**Case Officer:** Catherine Harker      **Recommendation:** Approve

**Applicant:** Sir Stephen Gomersall

**Proposal:** Relocation of staircase, minor internal alterations associated with staircase and alterations to a single window and external door

### Proposed Sheet 1

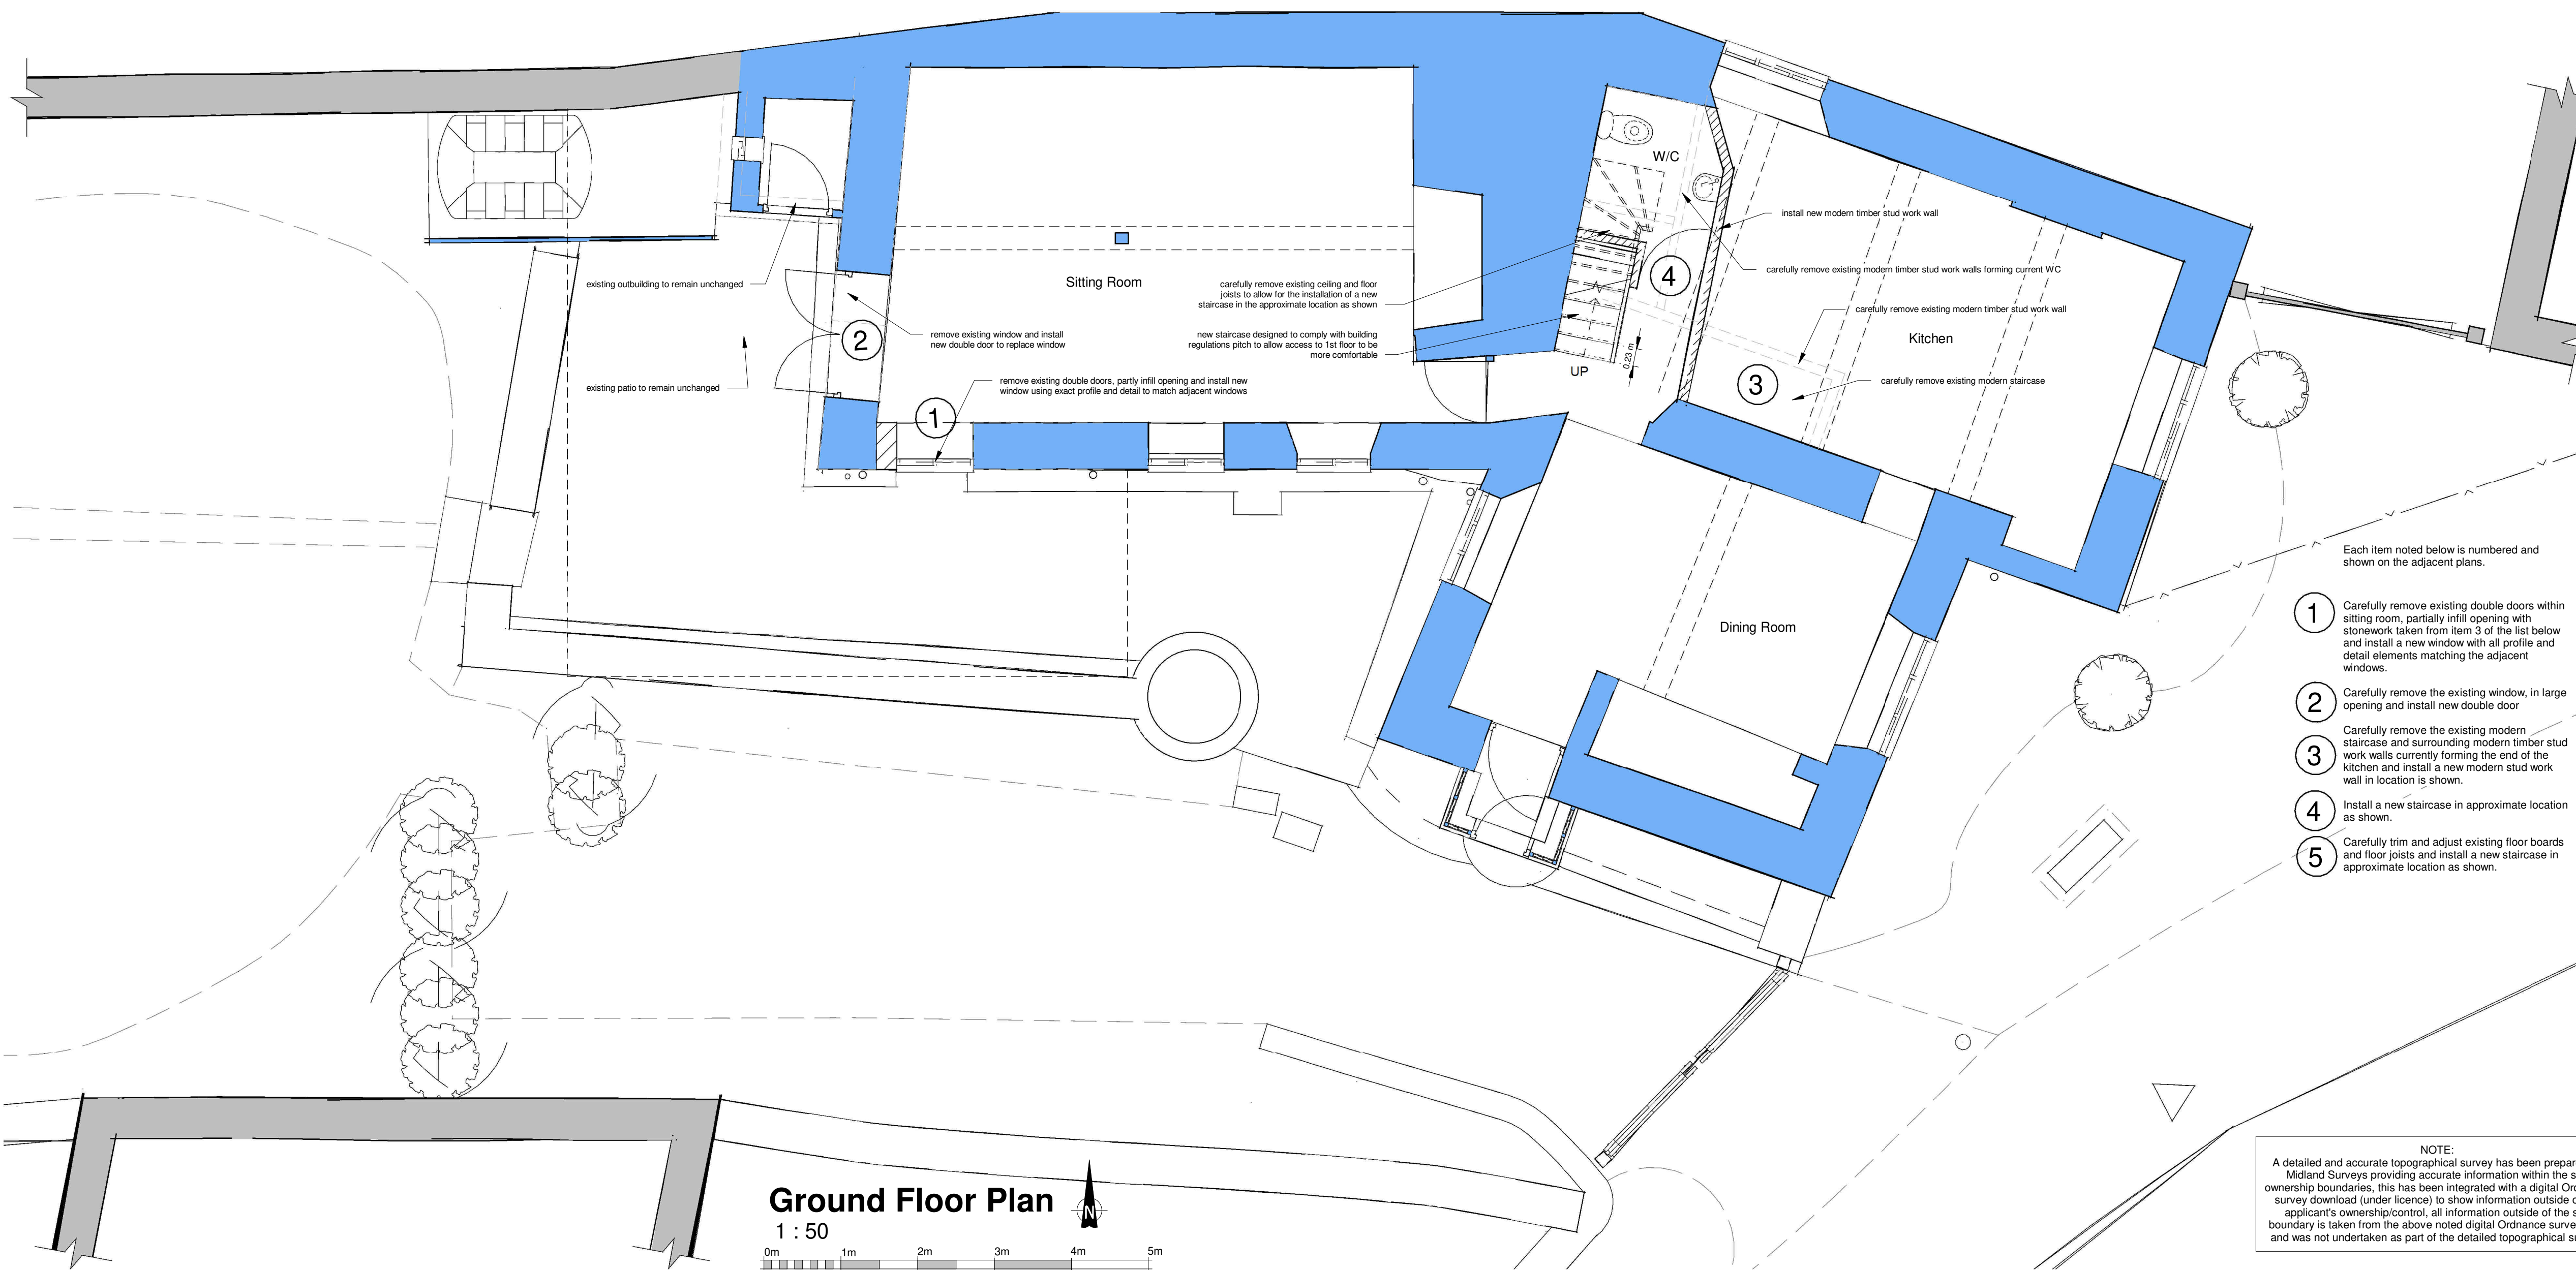
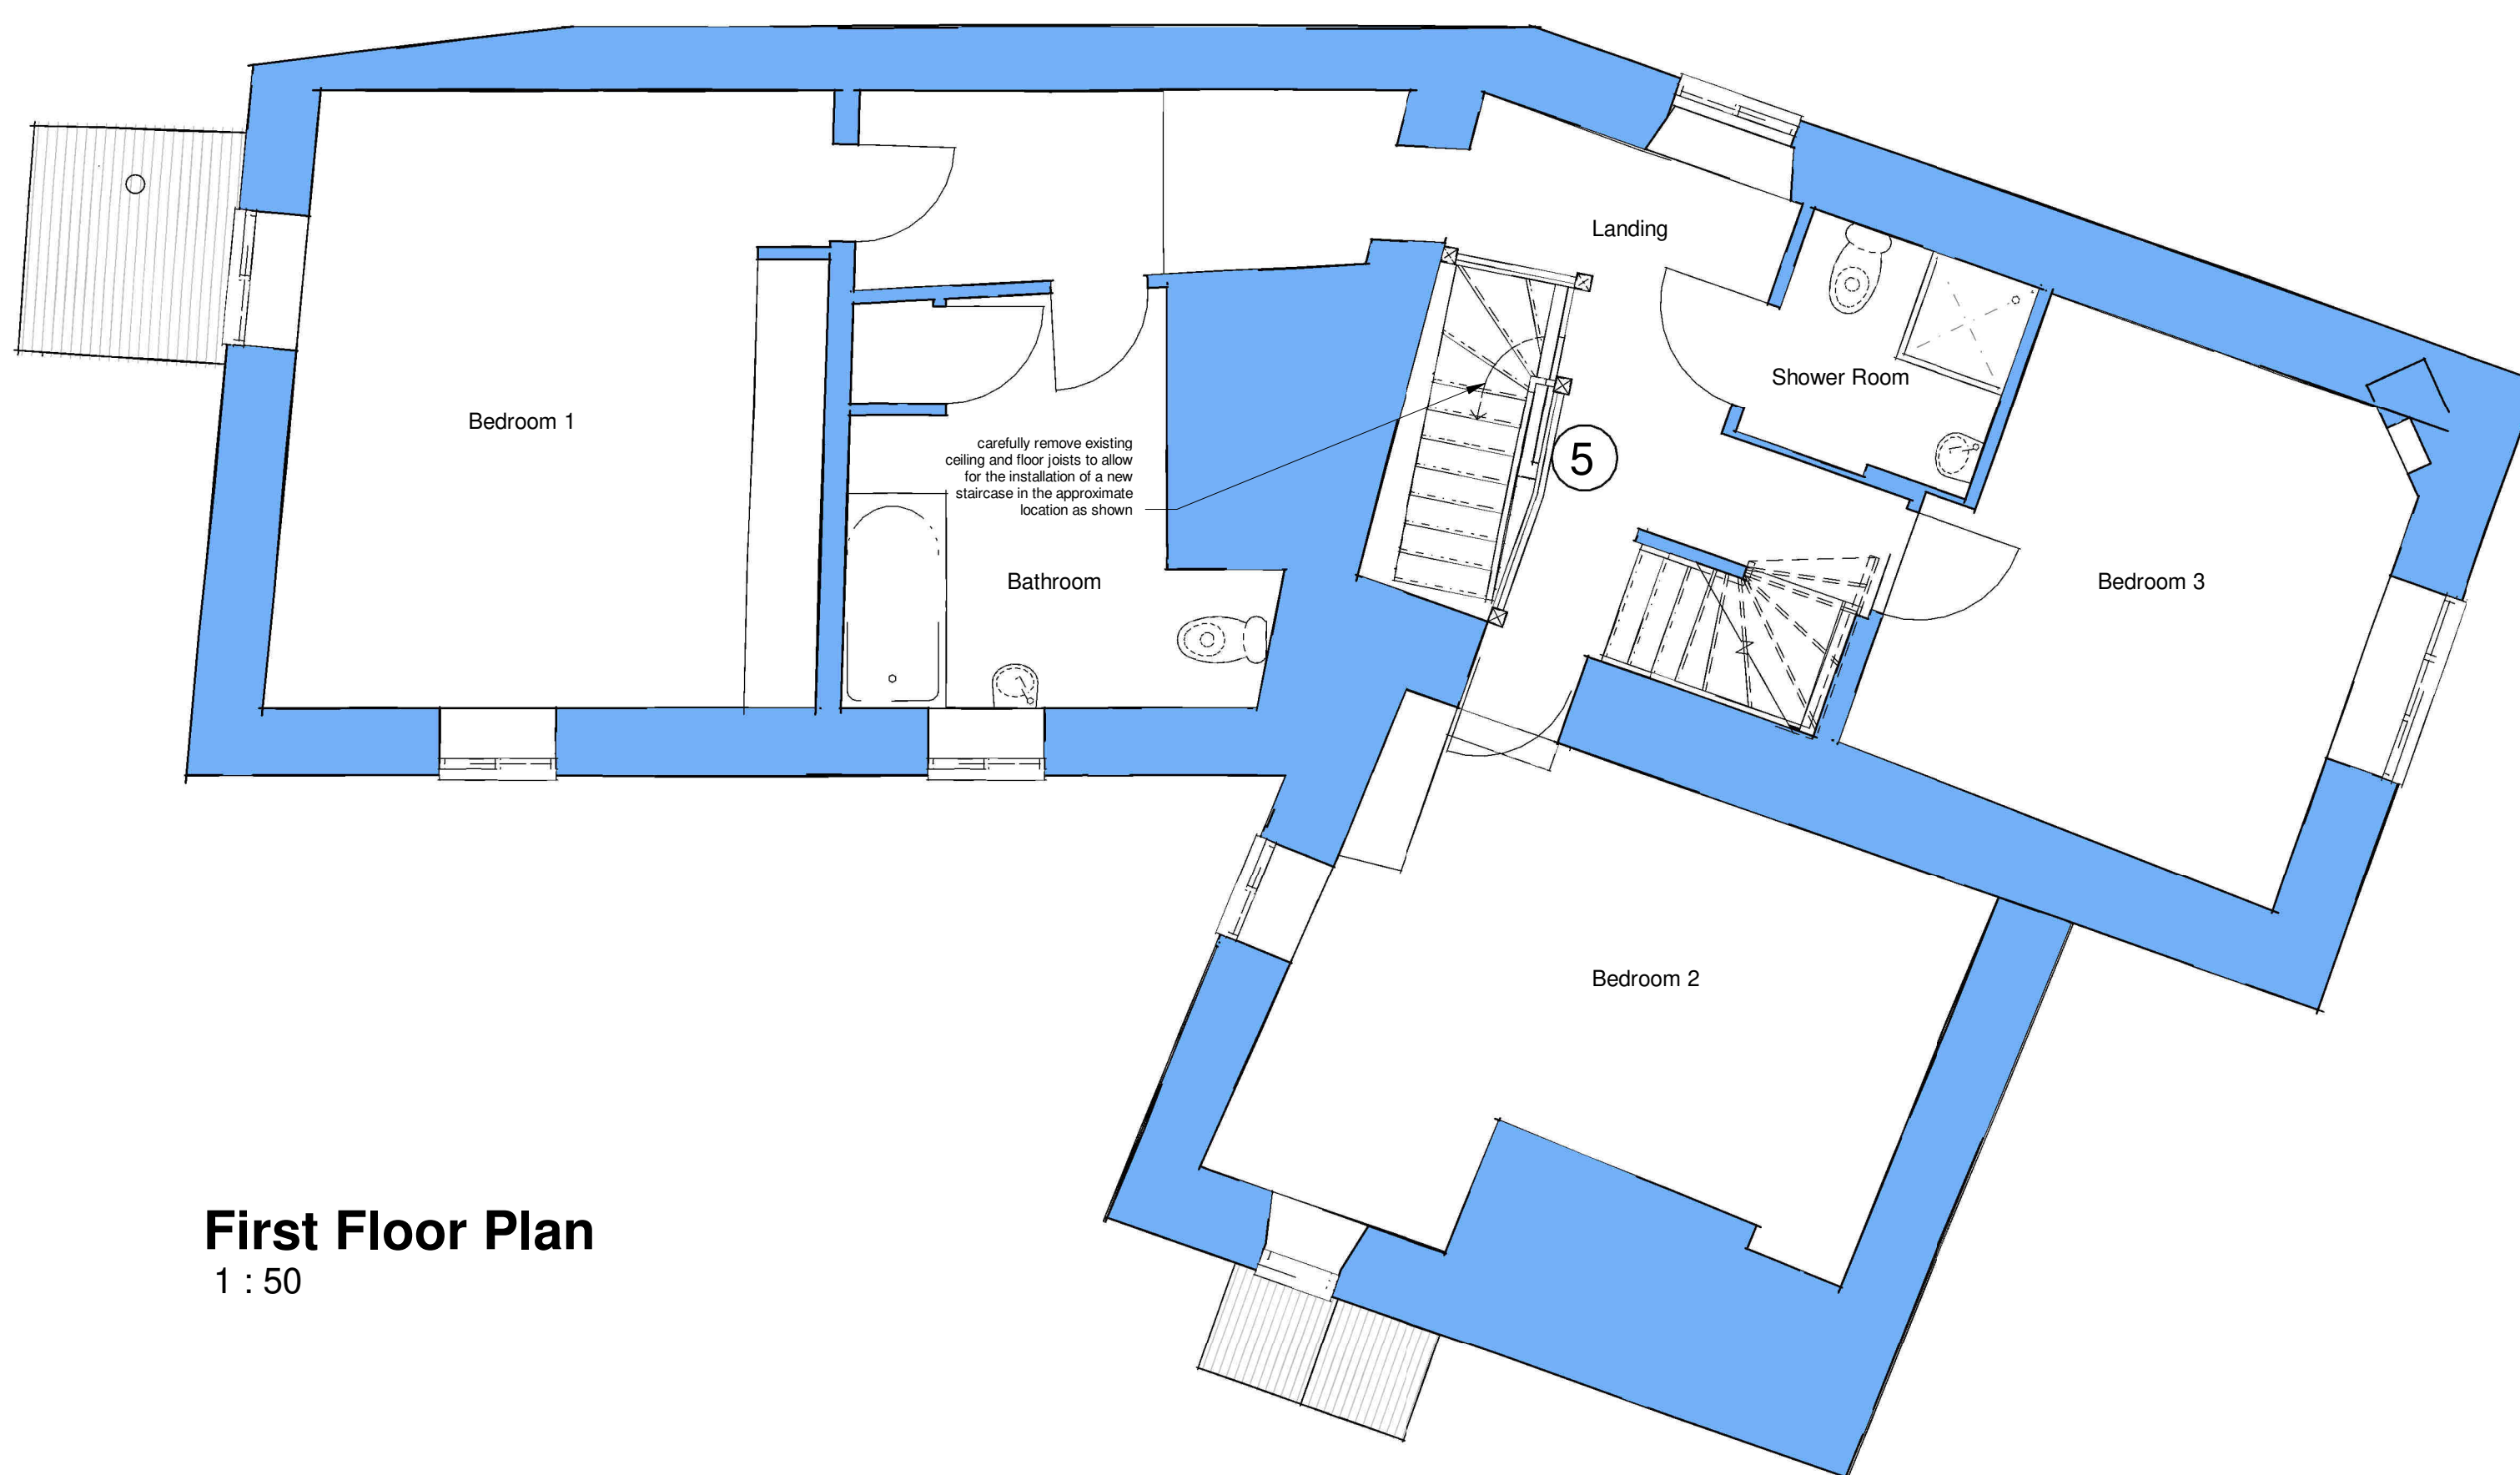
The previous application did not provide any evidence or explanation about the remaining nib of historic fabric to the south end of the 1980s downstairs toilet.

The current Heritage Report states 'The proposed new location will involve the removal of a small part of an existing wall currently projecting into the eastern range of the building to provide clearance for the staircase. It does not appear to have any structural role, and given the suggested phasing of the evolution of the house, it is possible that this is a piece of walling from a building which the eastern range later replaced? It does not appear to serve any obvious historic function.

The opening up work shows no soot / scorch marks on the upper floor nor any large stonework / soot / scorch marks around the historic nib of walling – and therefore nothing to suggest that there was an inglenook fireplace in this location.

There are therefore no objections to the granting of consent for a staircase in this location, but further recording work should take place during the course of works to ensure that any additional / new information regarding the stonework nib is recorded.

Further details are also required about the plumbing, drainage and ventilation for the WC, which should re-use existing routes wherever possible.

5. Prior to the installation of the bathroom, details of the new pipework for drainage, water supplies and soil stacks and details of any ventilation required, showing minimal harm to the historic fabric of the building, shall be submitted to and approved in writing by the Local Planning Authority. The works thereafter shall be undertaken in accordance with the approved plans.
